200: **SITE PLAN**

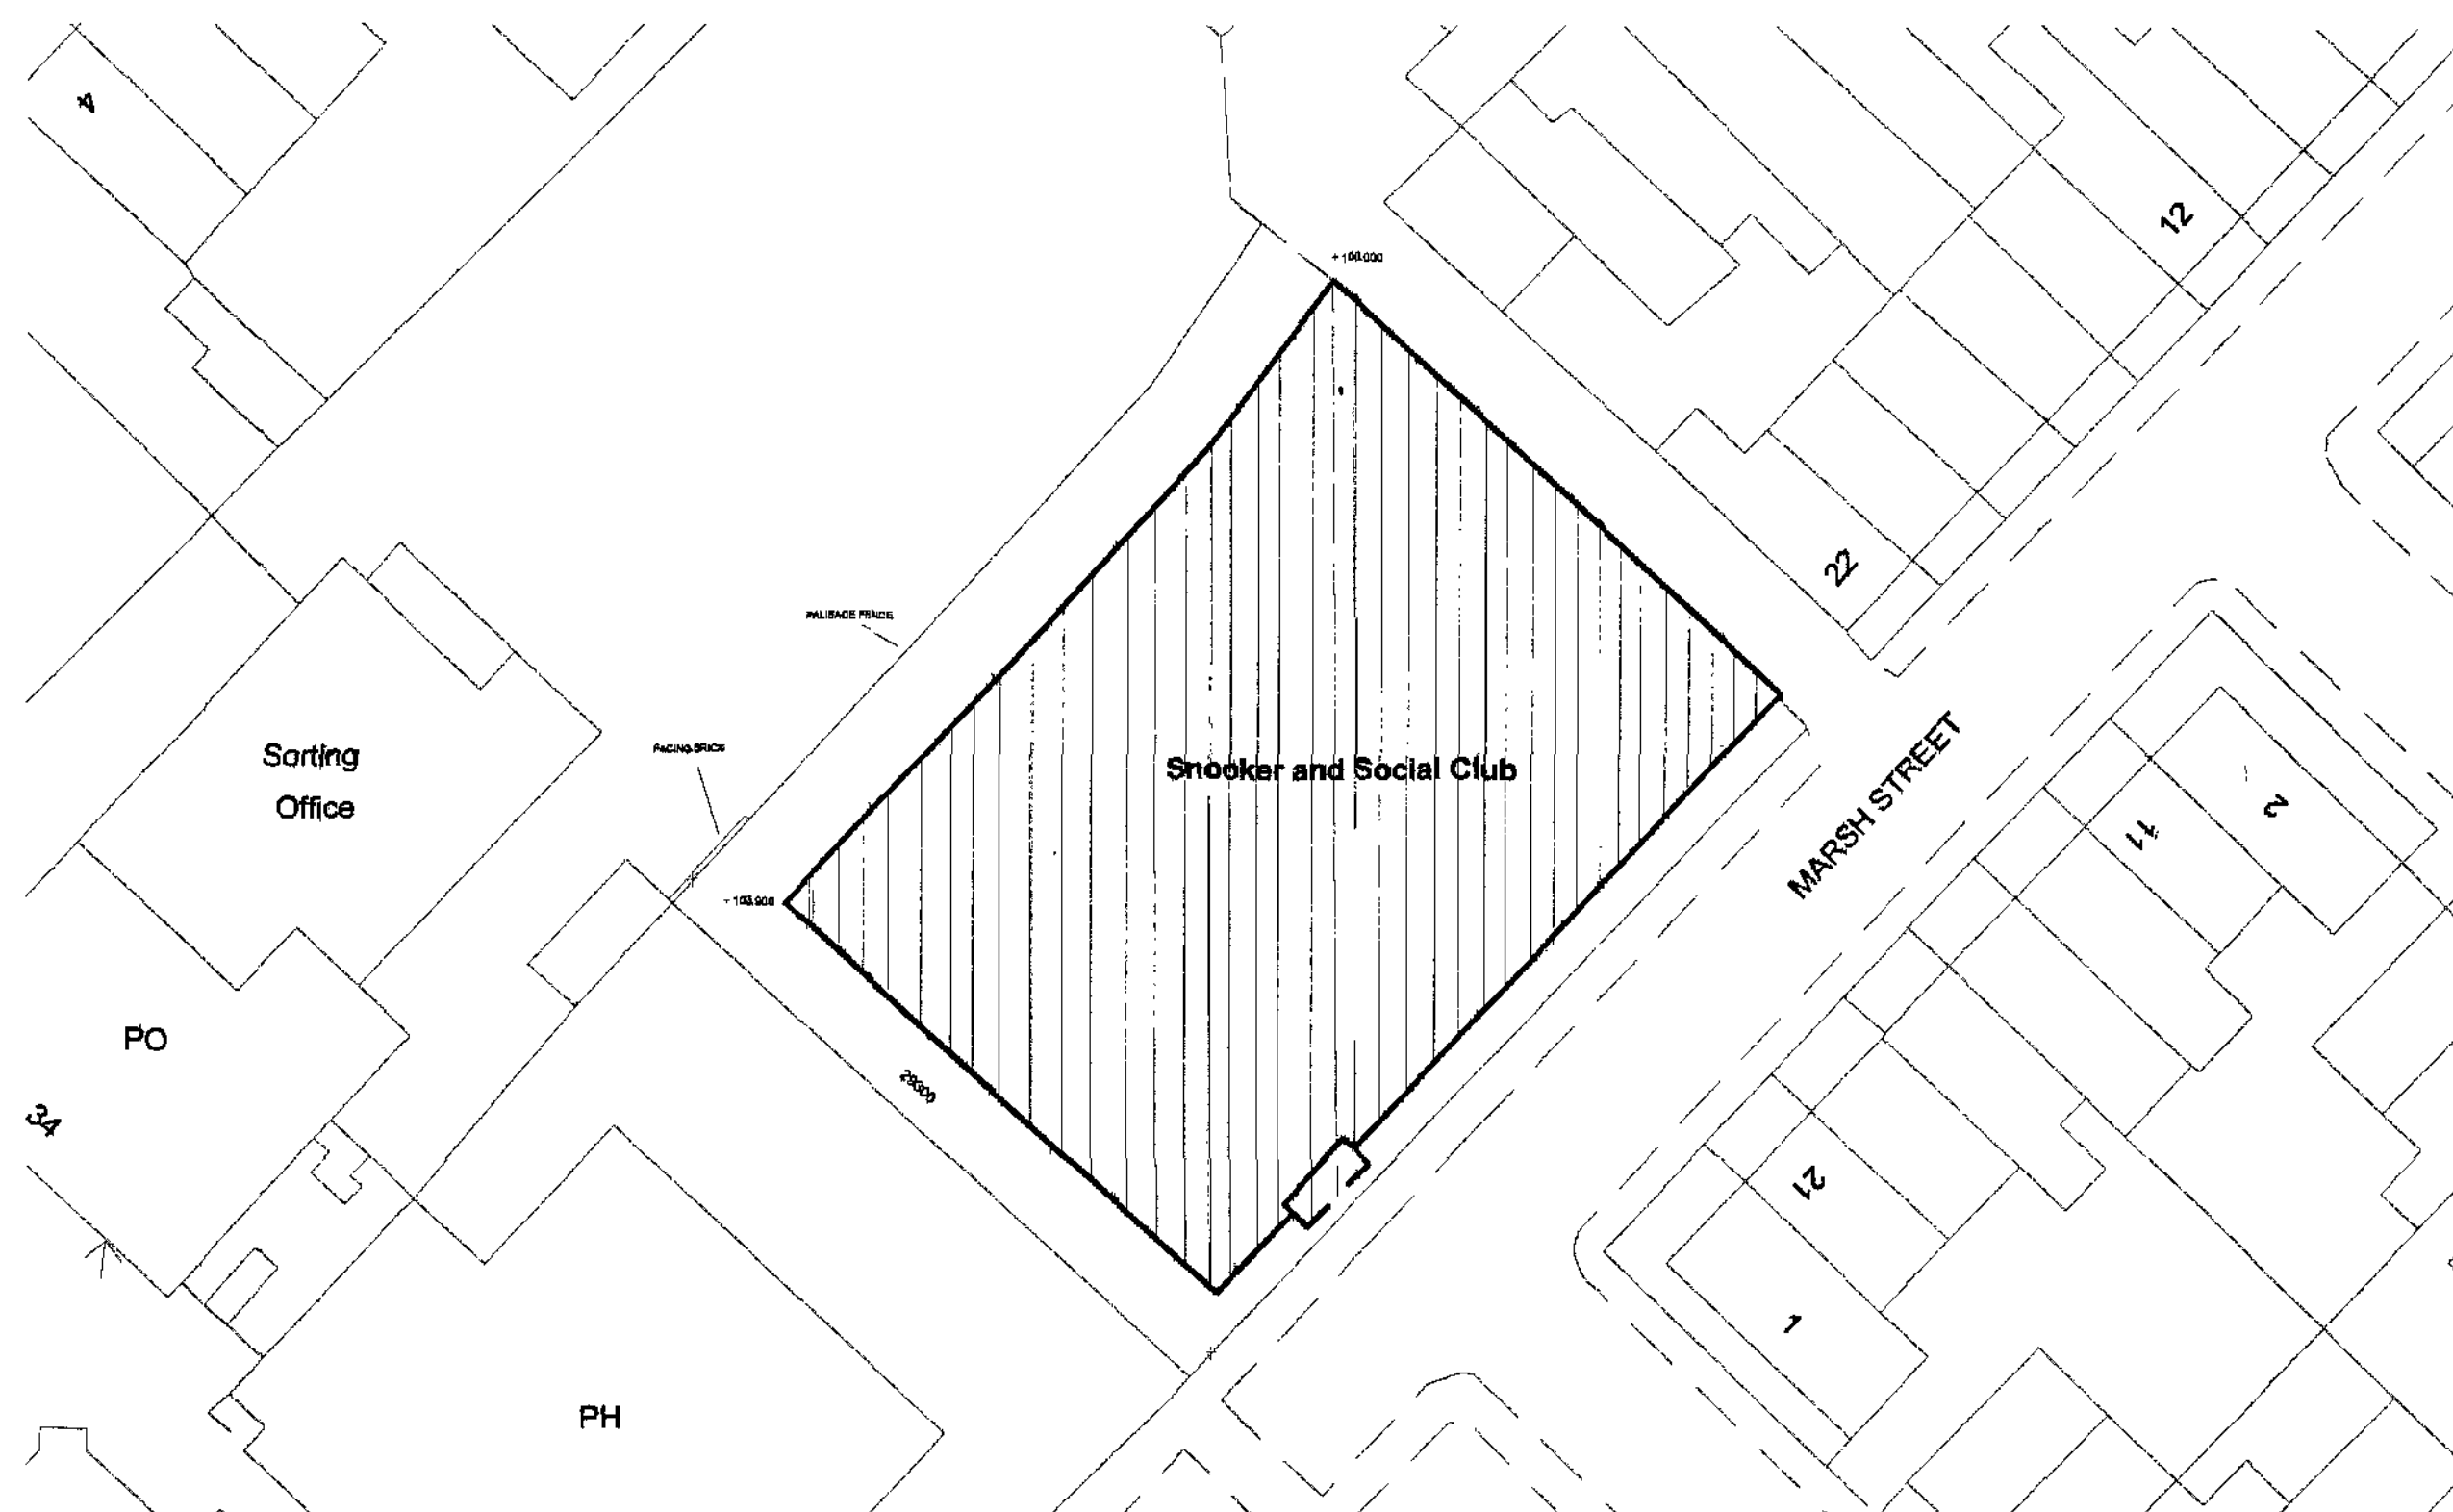
The flats would be more secure if they had a secure rear parking area and some defensible space around the front. Access around the sides of the development should be secured with a lockable gate or just fenced off, as close to the front building line as possible.

I can condition gate and fencing details if you are in agreement. Otherwise, if you could mark gates around the sides of the development on a plan that would prevent the need for a planning condition.
